Appeal Decision

Appeal Ref: 6007587

79 Fairholme Crescent, Hayes, Middlesex UB4 8QU

- The appeal is made under section 78 of the Town and Country Planning Act 1990 (as amended) against a refusal to grant planning permission.
 - The appeal is made by Dylan Swift against the decision of the Council of the London Borough of Hillingdon.
 - The application Ref is 53556/APP/2025/1948.
 - The development proposed is the erection of a single storey extension to the side/rear and conversion to a self-contained studio for a wheelchair user.
-

Title: **PROPOSED ELEVATIONS**

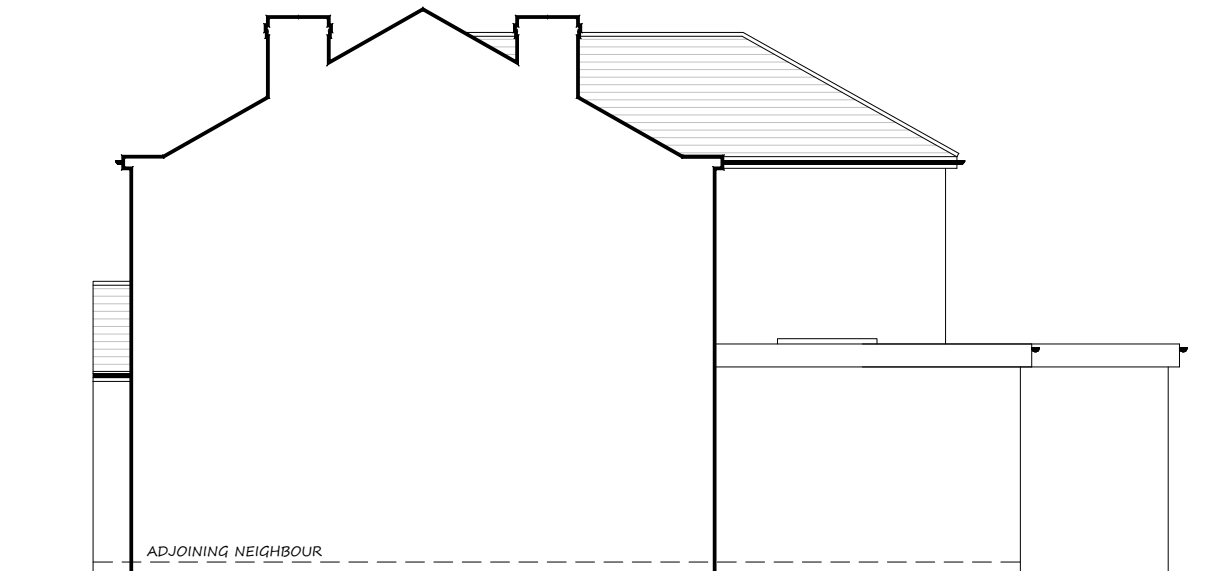
7. By reason of being an independent single storey dwellinghouse with a predominantly flat roof, the design of the proposed development would appear an incongruous form of development within the streetscene that is primarily characterised by 2-storey semi-detached dwellings. There are some bungalows, but they have pitched roofs which reflect the design of the 2-storey dwellings and are of a similar width. This identified harm associated with the design of the appeal scheme would be accentuated by the narrow width of the proposed dwelling and the smaller size of the front window when compared to the surrounding dwellings.

8. There is a wide gap to the side of No. 79, and the proposed development would not be sited forward of its front elevation. However, the sub-division of the curtilage and the erection of an additional dwelling within this gap would result in the appearance of a cramped form of residential development. Although only single storey in height, the appeal scheme would also result in the appearance of a short terrace of 3-dwellings that would disrupt the predominant rhythm, character and appearance of the pairs of 2-storey semi-detached dwellings fronting this part of Fairholme Crescent. The potential use of external materials to match those of No. 79 would not mitigate the unacceptable harm which has been identified.

Title: **PROPOSED FLOOR PLANS**

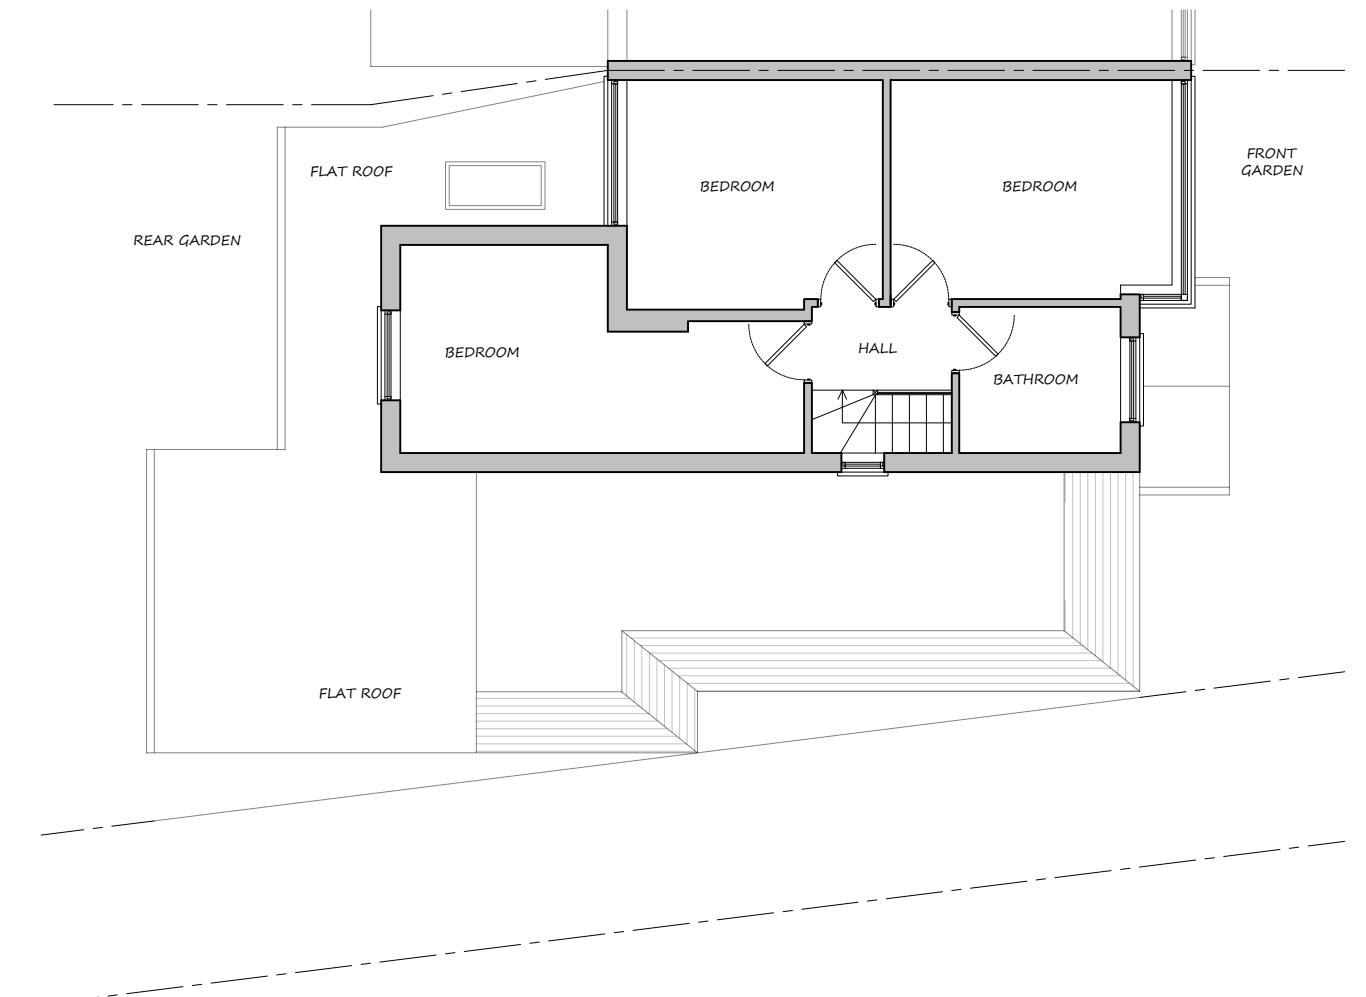
6. The erection of a domestic single storey side extension to No. 79 to create additional living space for its occupiers would reflect the bulk and scale other additions that have been erected within the surrounding area, including at Nos. 77 and 110. However, the proposed development would result in the creation of a separate dwellinghouse which is intended to be a self-contained studio for a wheelchair user, rather than being a domestic extension to No. 79.
